SCOTTISH POWER – EAST ANGLIA ONE NORTH AND EAST ANGLIA TWO

REFS – 20024254 & 20024255 – DEADLINE 13

**DEADLINE 13 - SUBMISSIONS BY MICHAEL MAHONY, [REDACTED]
FRISTON IN RESPECT OF DRAFT DCOs SUBMITTED BY THE APPLICANTS AT
DEADLINE 12**

Drawn:	PR
Approved:	HH
Sheet No:	9 of 13
Sheet Size:	A1

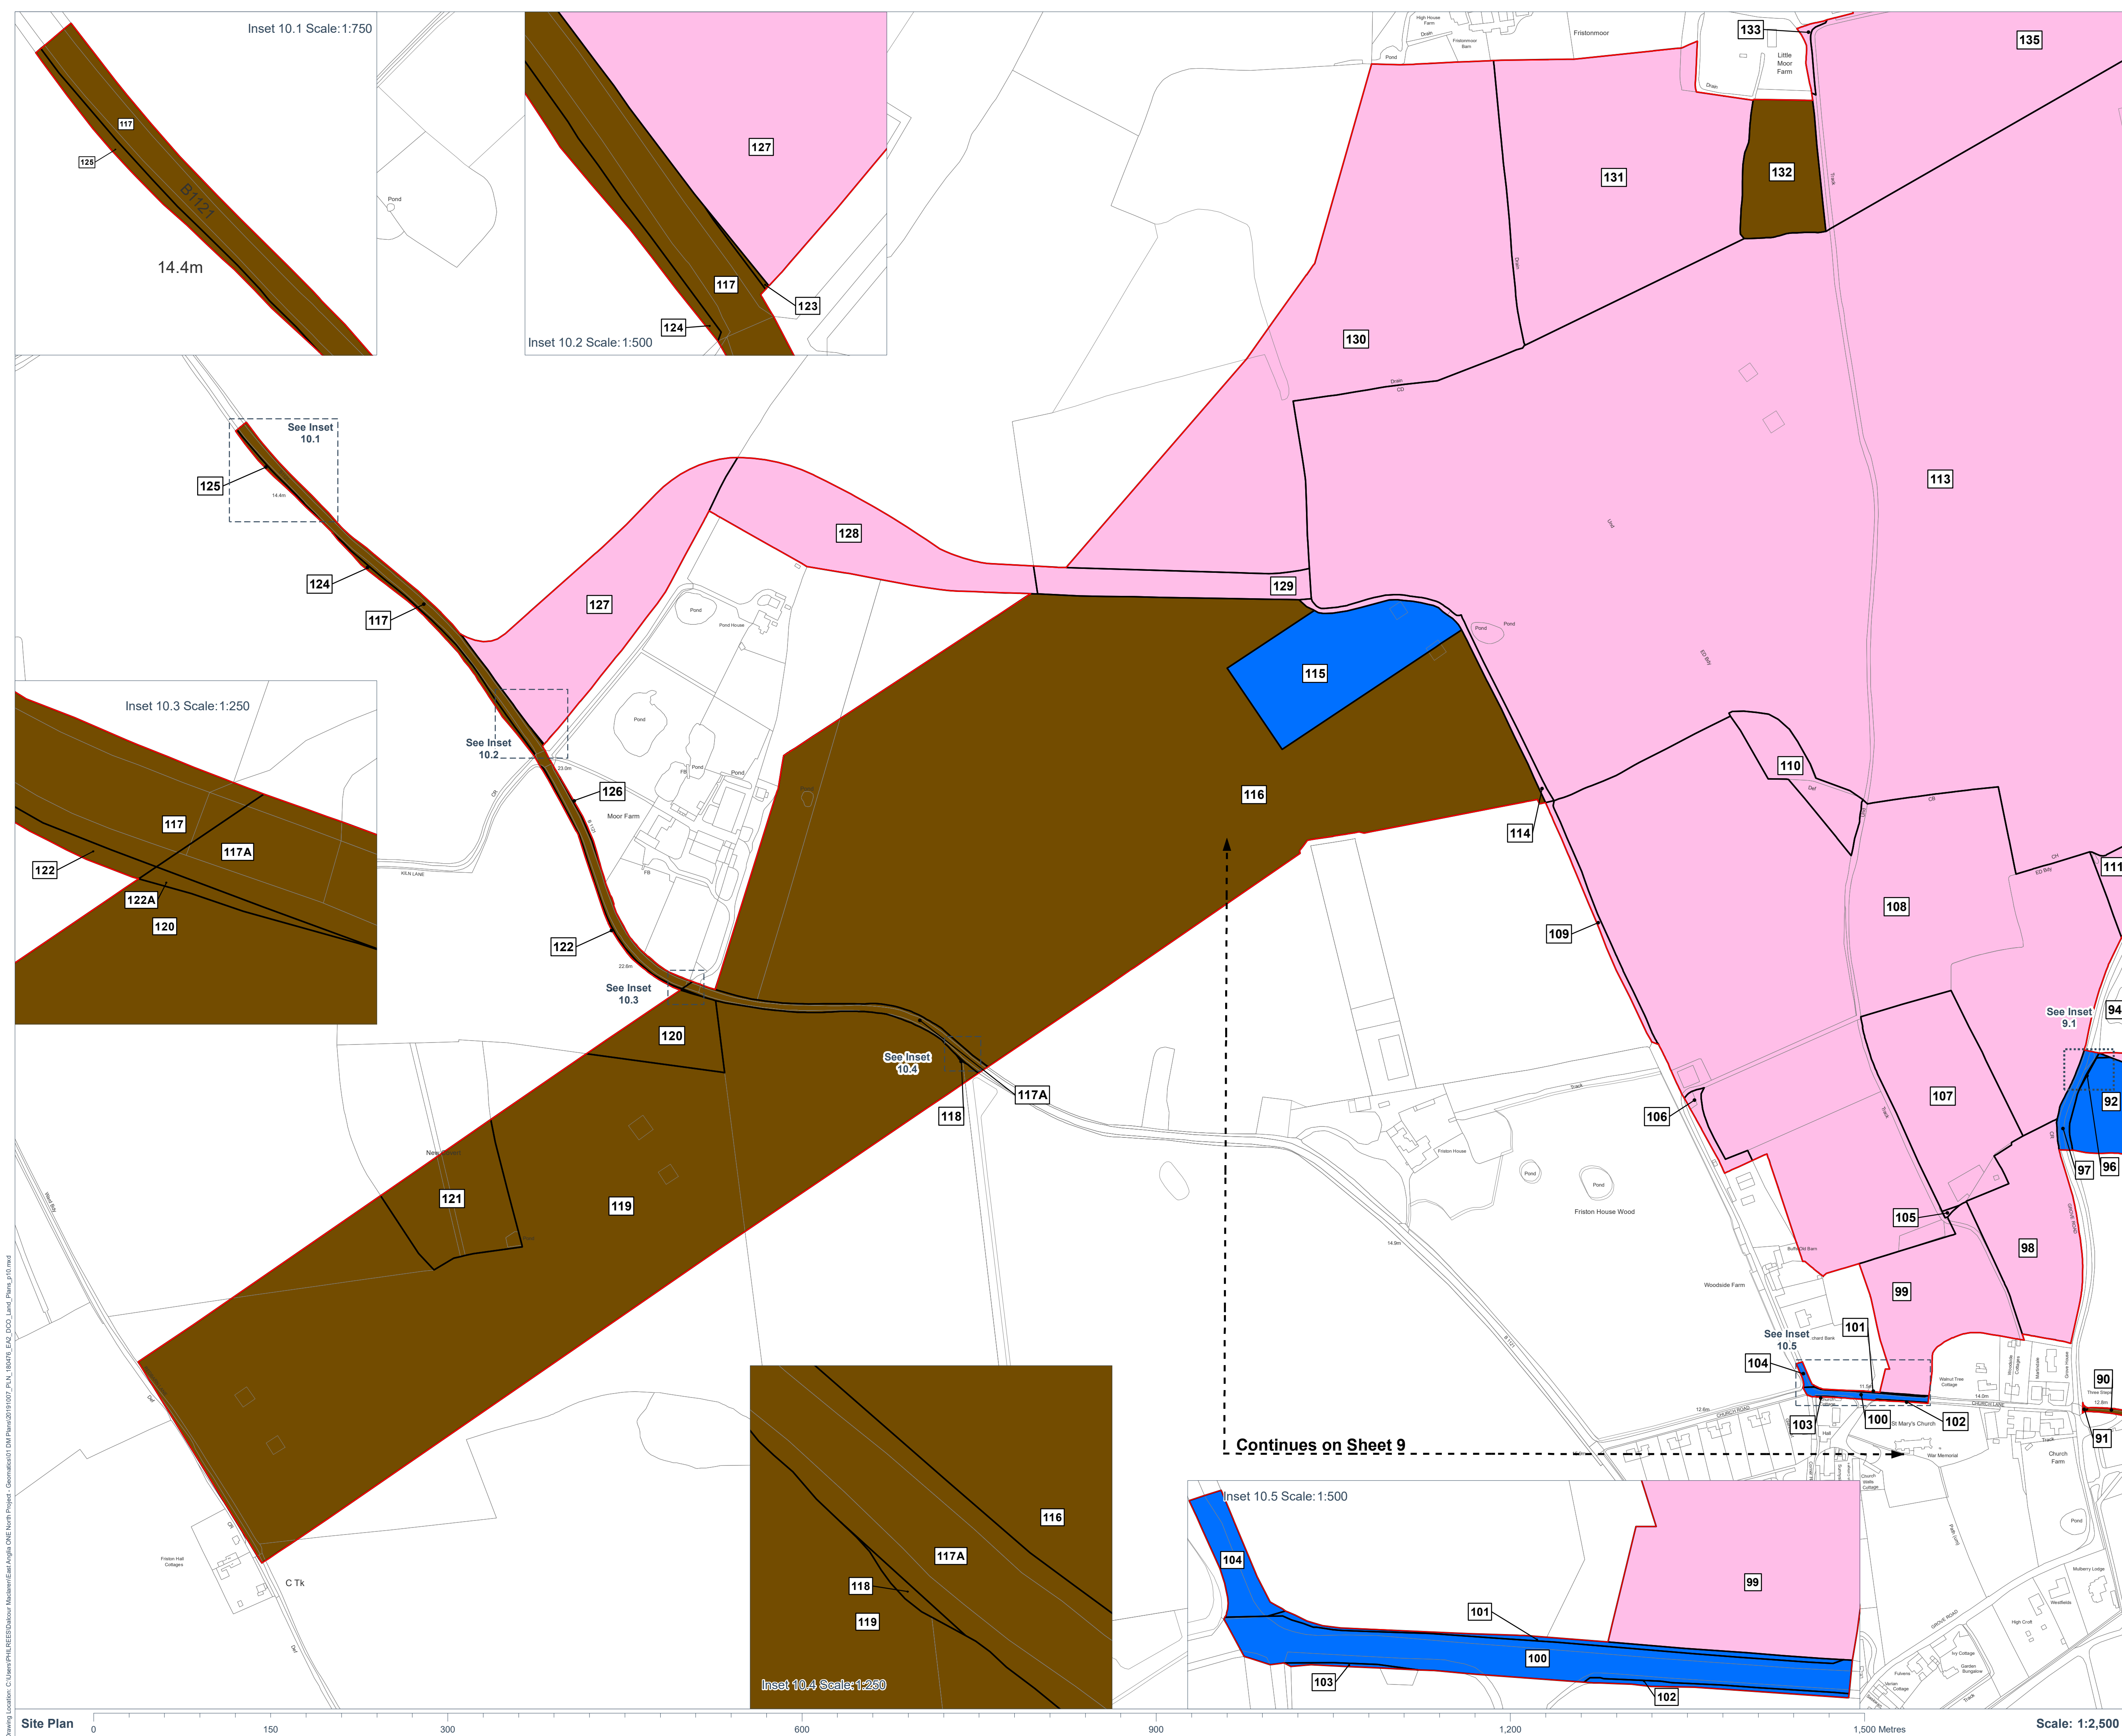
3. This is untrue. The Works Plans (REP11-004) sheet 7h of 12, sheet 7i of 12 and sheet 7l of 12 show that only works 39 (pylon realignment works), 40 (temporary pylon realignment works) and 43 (temporary working areas for works 39 and 40) respectively are taking place on plots 115 and 116 as shown in the Land Plans (REP11-003) sheet 9 of 12.

6. Accordingly column (3) and column (4) of Schedule 9 to the DCO need to be corrected to conform with the amended Statement of Reasons (in accordance with my previous submissions) and with the Works Plans and Land Plans, so that the Applicants and National Grid do not acquire, inadvertently or otherwise, greater rights than are required or can be justified in respect of the projects.
